The Coal
Authority

Re: Planning application 2025/62/93355/E

Erection of 75 residential dwellings with associated landscaping, open space, highways and drainage infrastructure at Land off Woodward Court, Mirfield, WF14 0PY

The Coal Authority response: SUBSTANTIVE CONCERN

SCALE	1:1250	SHEET	A3	DRAWING NO.	5670/20	REVISION	E
-------	--------	-------	----	-------------	---------	----------	---

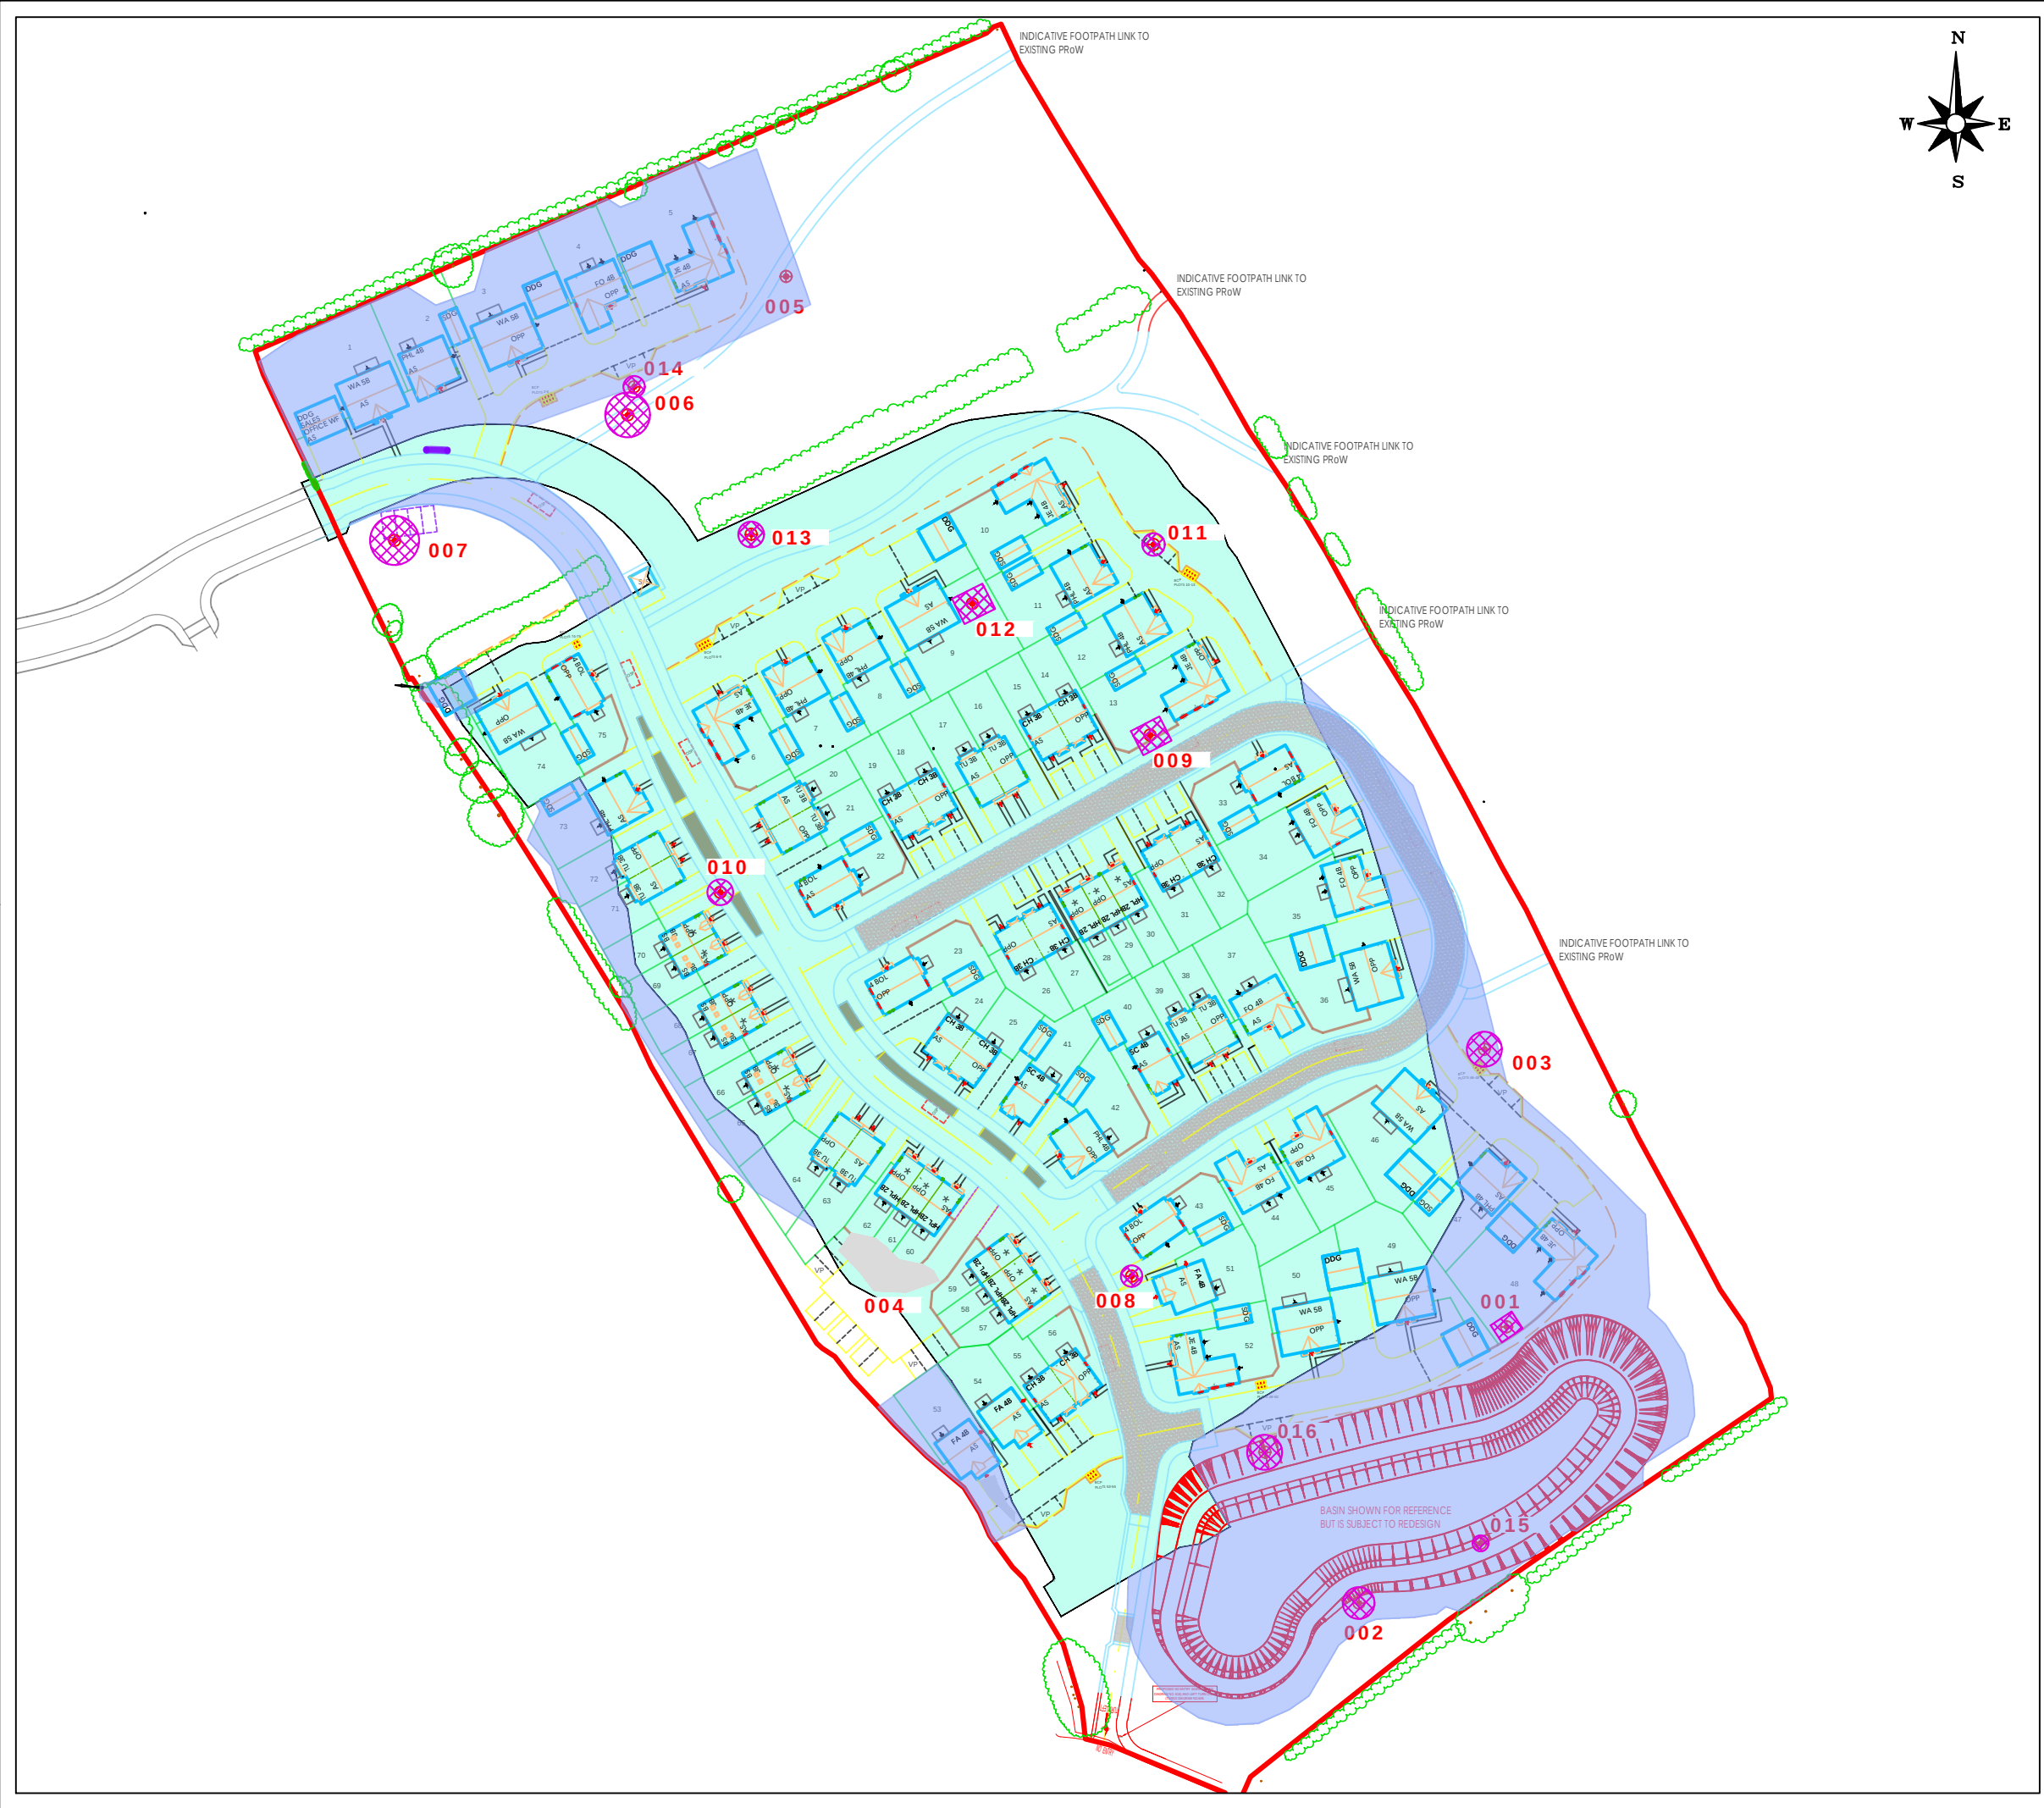
- A previous partial soil strip was carried out at the site, as shown on the Mining Features drawing contained in Appendix B, which encountered a number of previously unrecorded mine entries. This soil strip did not extend across the entirety of the parts of the site where development is now proposed.

- Given the number of unrecorded features encountered previously, we assume that the applicant has undertaken a further soil strip across the additional development areas in order to establish whether any unrecorded mine entries are present within these parts of the site. In consideration of our adopted policy mentioned above, we assume that the layout of development has been suitably informed by the presence of any such features encountered.

- Should soil stripping of the additional development areas have not been carried out, we consider these further investigations should be undertaken prior to the determination of the application to ensure that any unrecorded mine entries present are identified and in order to inform the detailed layout of development under consideration by the LPA.

- The location of all mine entries encountered on site and their associated zones of influence / no-build zones should be clearly shown on the proposed Site Layout plan.
